reminder re 30 Merrill

The proposed 30 Merrill Street project contains substandard landscape treatment that provides little if any of the usual Site Plan values and standards expected on similar residential developments. Proposals of this kind that use +/- 98% of the available space for built structure and hardscape present challenges for Landscape Review using traditional Technical Standards methods along with the expectation to have new residential projects 'fit' into the neighborhood. We have heard public complaint on the lack of landscape treatment in general on Munjoy Hill and this neighborhood on this topic. The proposal for 30 Merrill Street should include landscape and buffering treatment to meet standards.

13 FENCE DETAIL NEAR CURB  
SCALE: 3/4" = 1'-0"

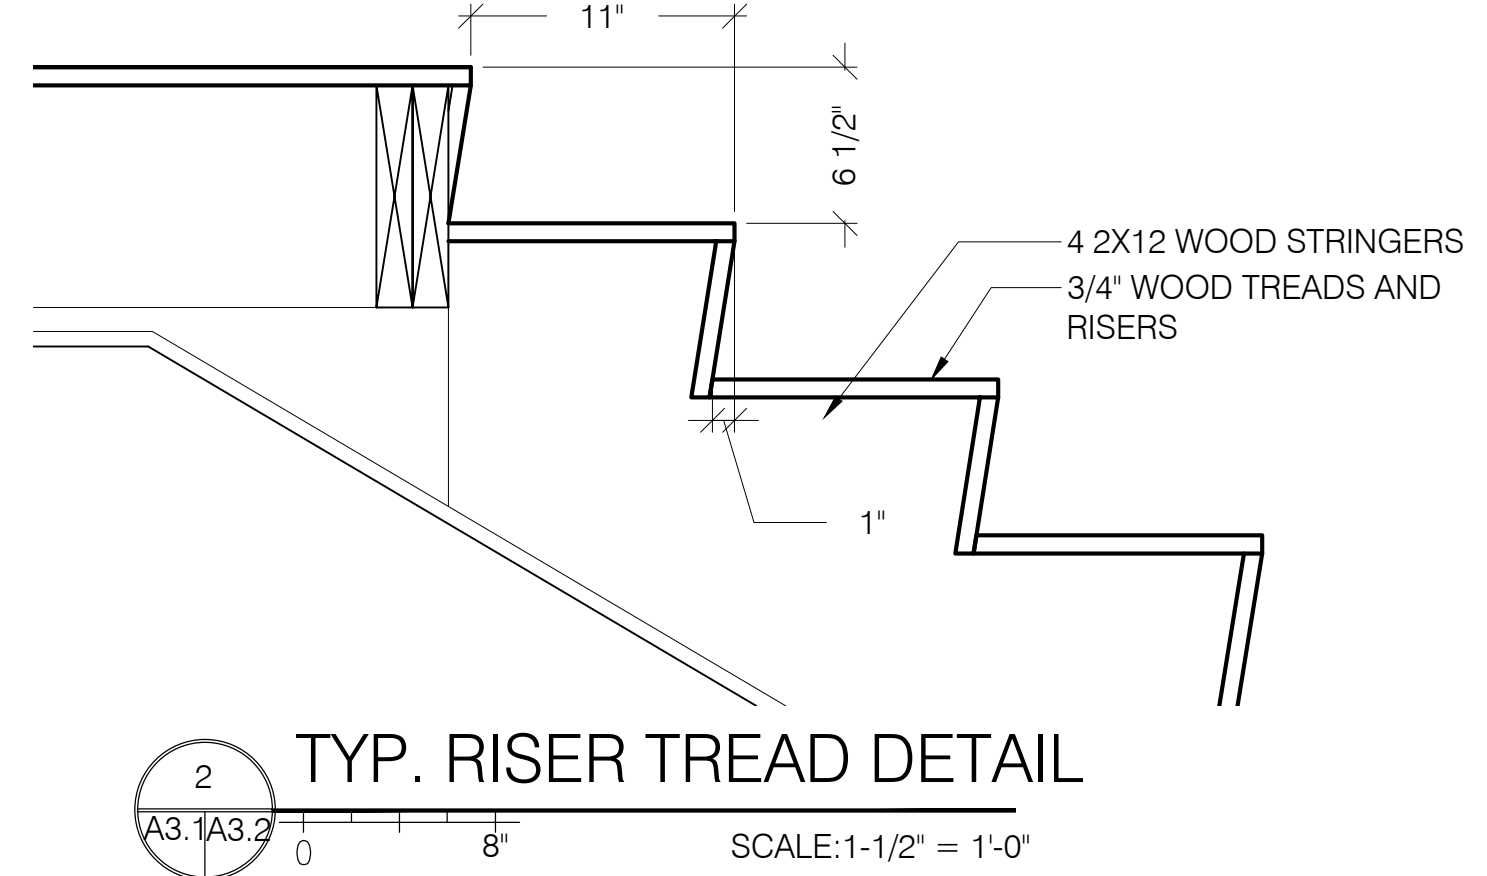
At a minimum, the proposed fence detail should wrap the entire property on three sides as the current fencing does. (see photo). Buffering / landscape for the side and rear yards should be included. The use of 'green screen' or similar treatment is warranted for the parking area if the building footprint remains. The snow storage area should have landscape and trees that can withstand snow storage, this needs to be defined. The melting snow and possible deicing salt could impact neighboring properties not to mention landscape & trees.

PROJECT NAME: SIX-UNIT BUILDING 30 MERRILL STREET
 PORTLAND, MAINE
 SHEET NAME: SITE LAYOUT PLAN

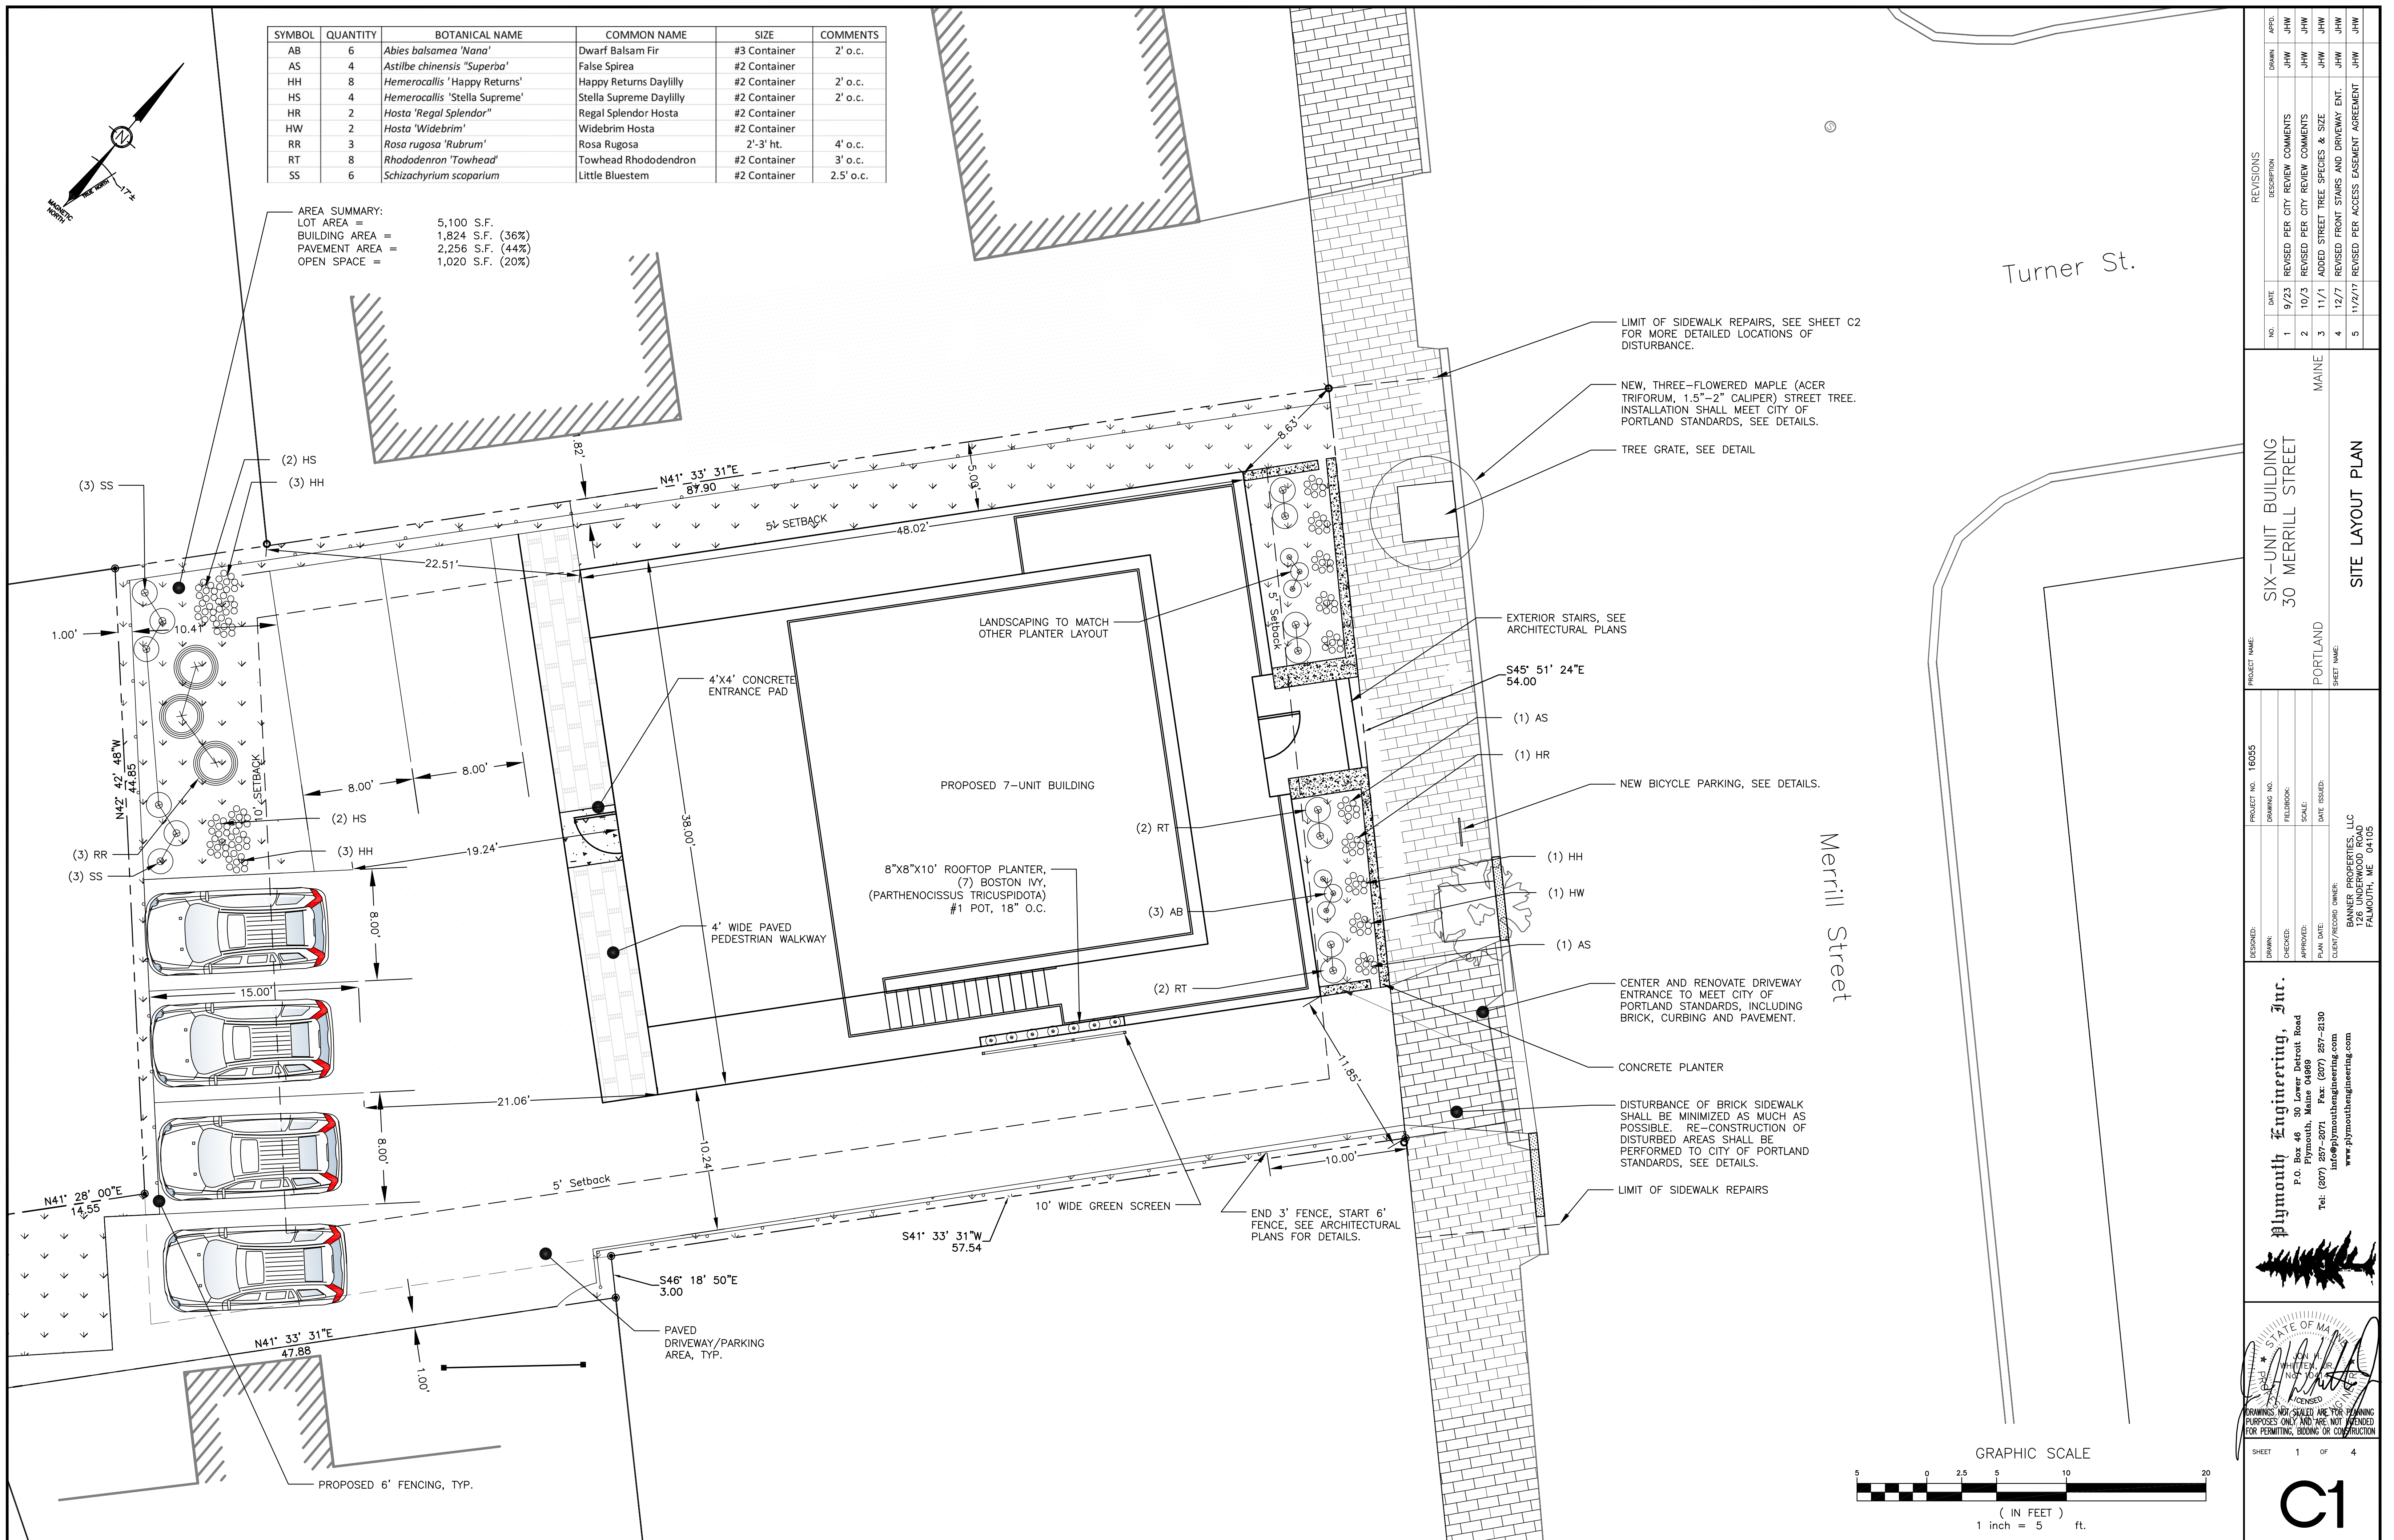
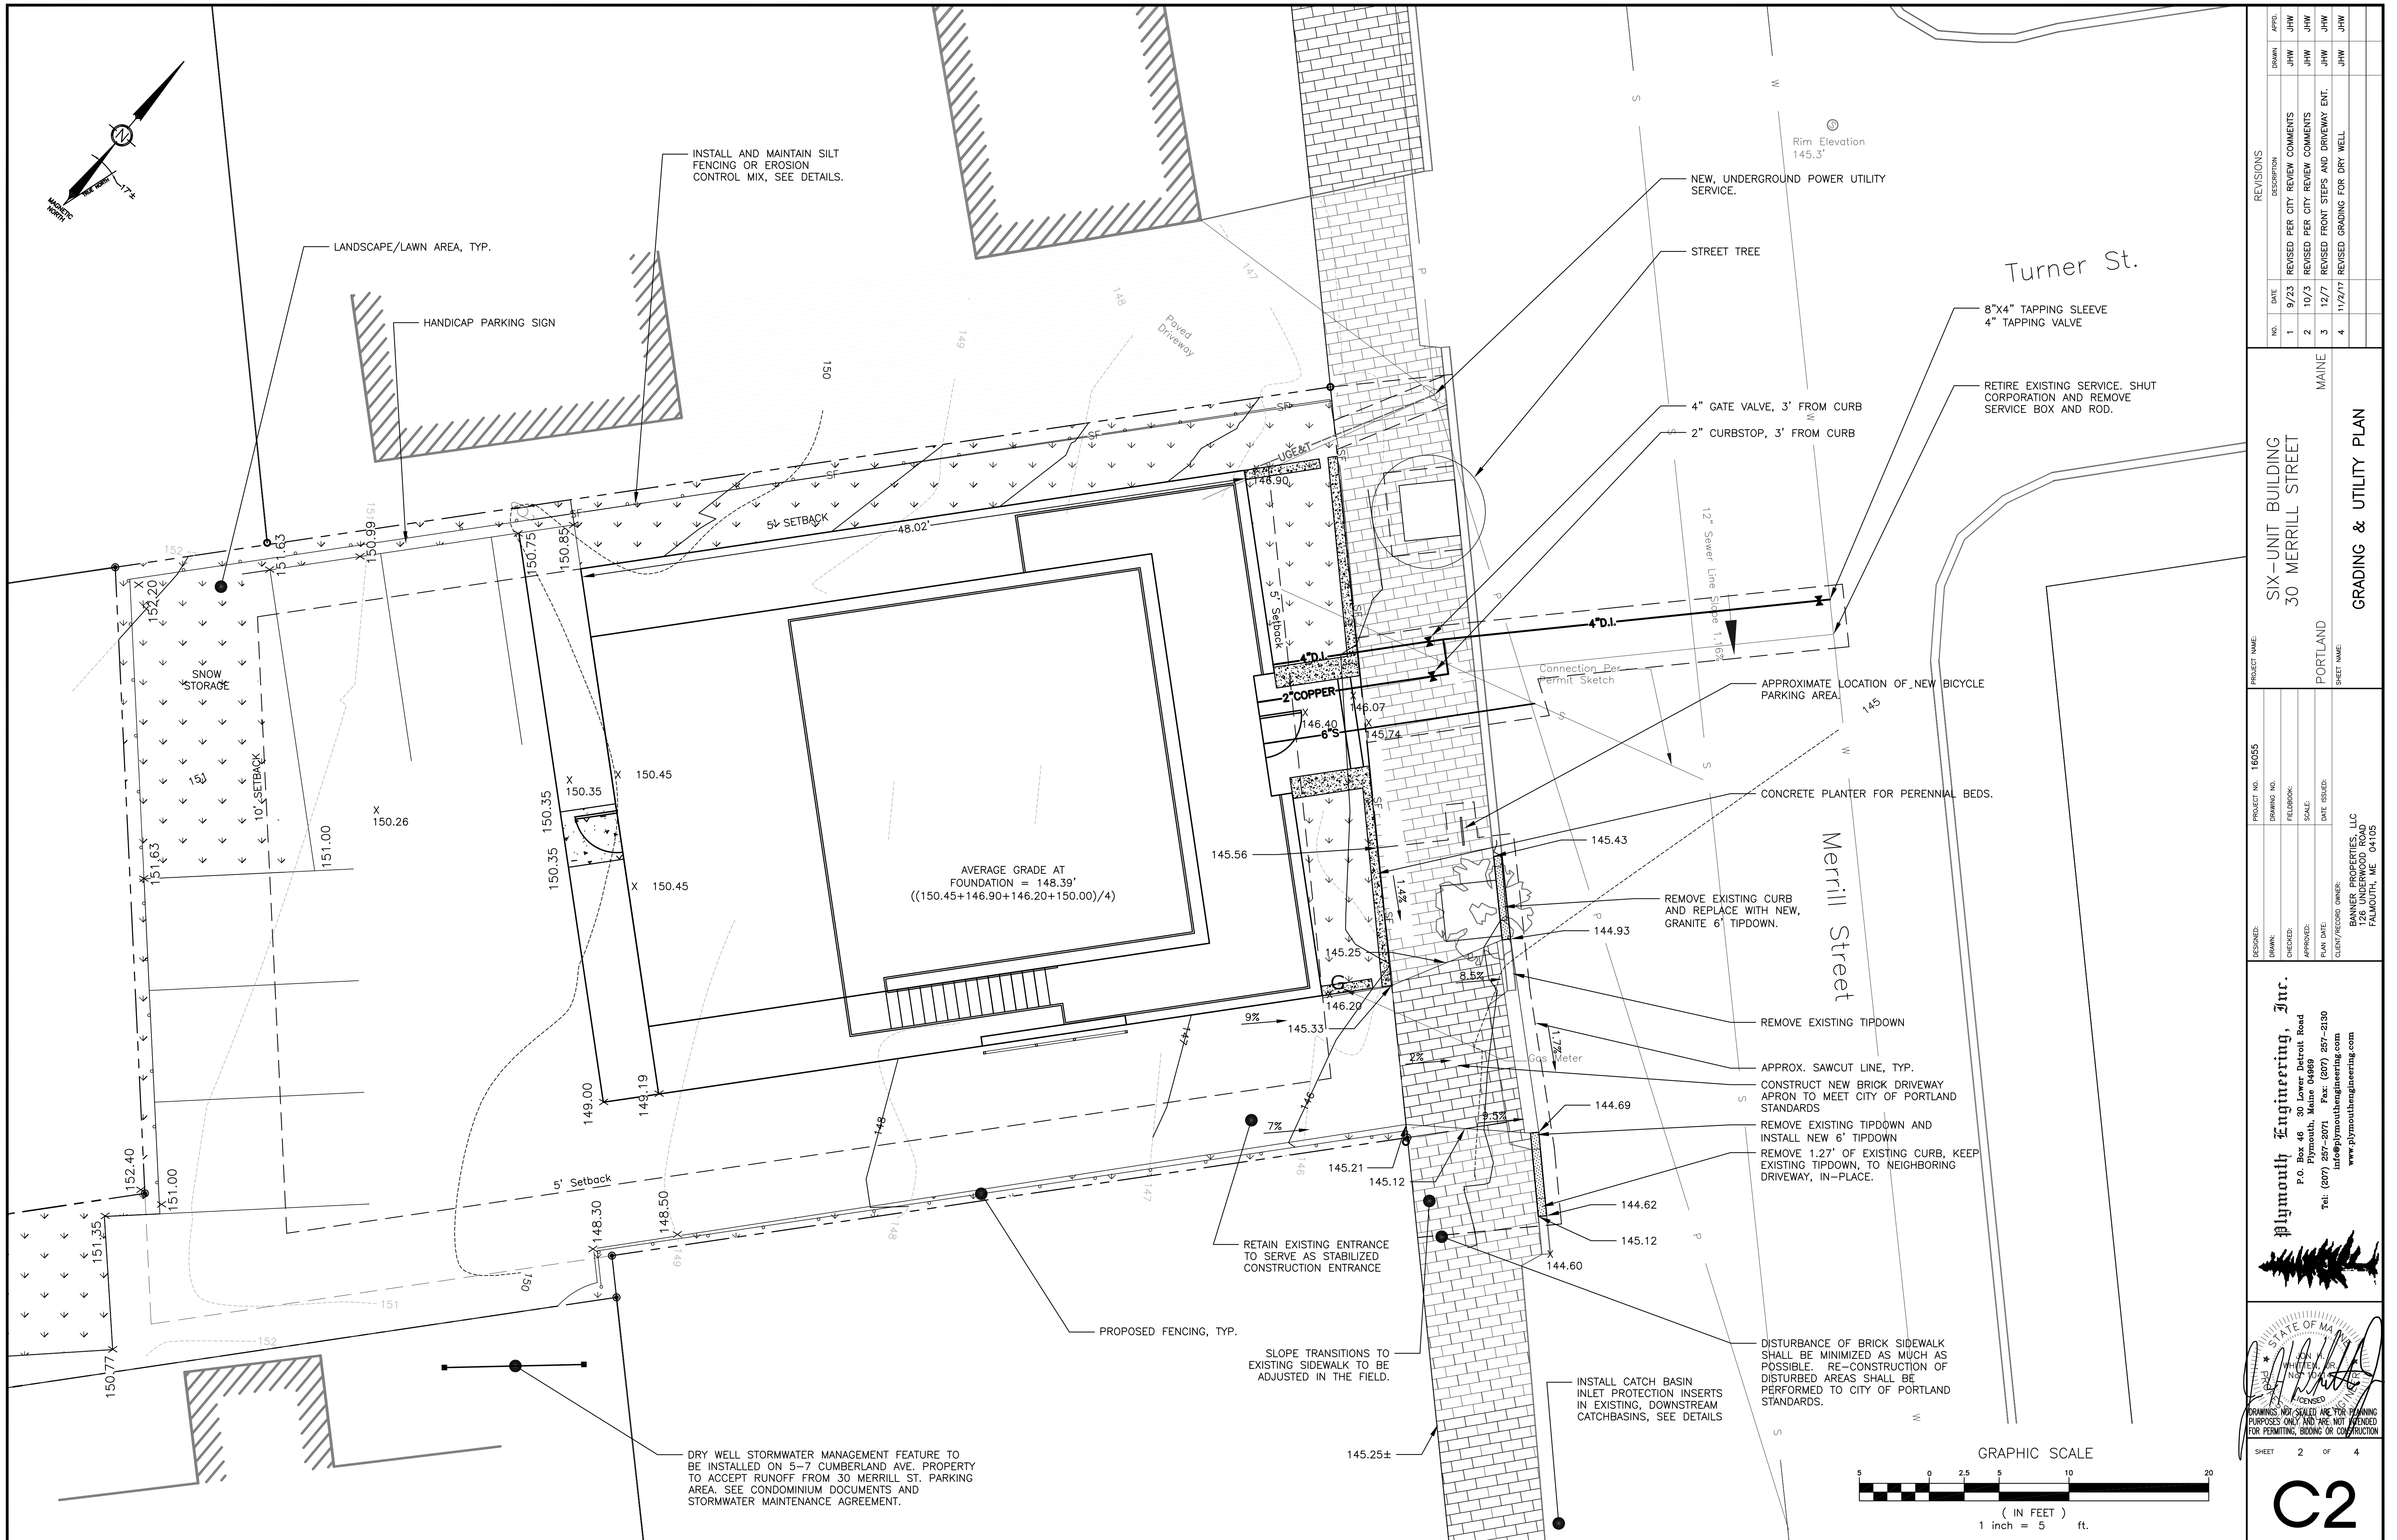
A condition of approval would be to refine the plans to include defined landscape elements.

Street-trees - The project should include two street trees, to be determined by the City Arborist and project team, knowing they are to be planted under overhead utility lines. These street trees should include granite planter or protective element roughly 4' W x 8' L. Additional donation to the Tree Fund can help plant trees in the neighborhood to meet the per unit tree standard. The existing tree is very likely to have construction impact from experience.

Front Landscape Planter - The proposed landscape area between the building and sidewalk should be part of the approved plan and should consist of both woody and herbaceous plant material. The planter may be large enough to include small dwarf or ornamental trees. This would be a condition of approval to have an actual design.

Side Landscape Treatment - The north side of the project appears to have room to include

landscape elements.

Overall, the size of the proposed development within the existing lot impacts the feel of the neighborhood. Additional landscape elements are needed.
